Attachment A – Concord Hospital Concept Proposal & Stage 1 Modification 7 (SSD-9036-Mod-7)

Response to Request for Additional Information

DRAWING No. MSCP-LS-DRG- 102

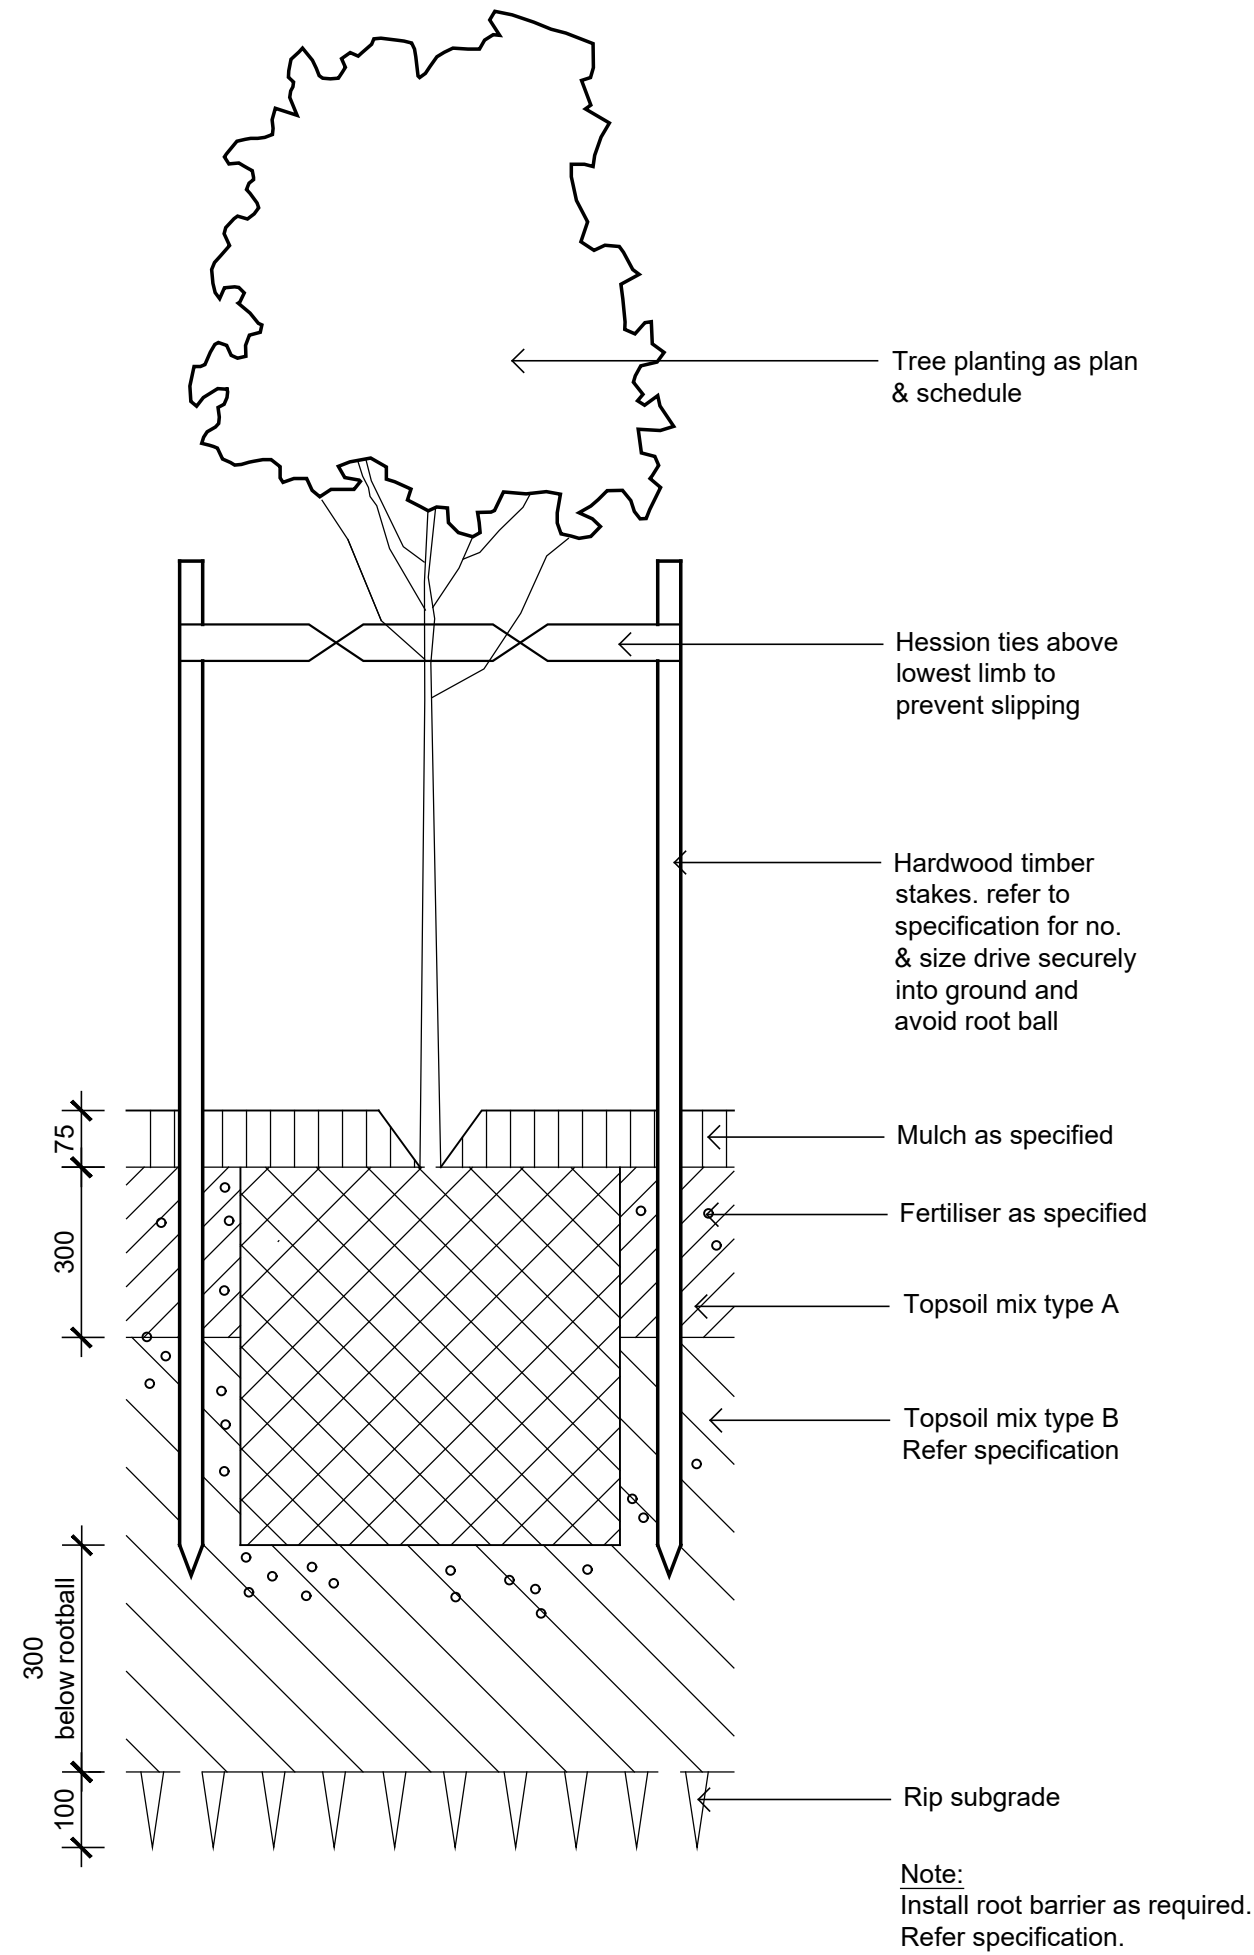
7	<i>EES usually recommends that the landscape planting uses a diversity of local provenance native species from the relevant native vegetation</i>	The proposed landscaping has been amended to use native plant species. The Landscape Architect has carefully selected plant species for

<i>community or communities that occur, or once occurred on the site rather than use exotic species or non-local native species. However, given the built-up character of the site and the existing conditions of consent relating to landscaping, EES would agree to other species being used in consultation with the Council. EES recommends that the RtS confirm that none of the species proposed for landscaping at the site have the potential to become weeds.</i>	landscaping at the site that do not have the potential to become weeds, given none of the species selected are listed as priority weeds for the Canada Bay local government area.
City of Canada Bay Council		
8	Response provided under separate cover.
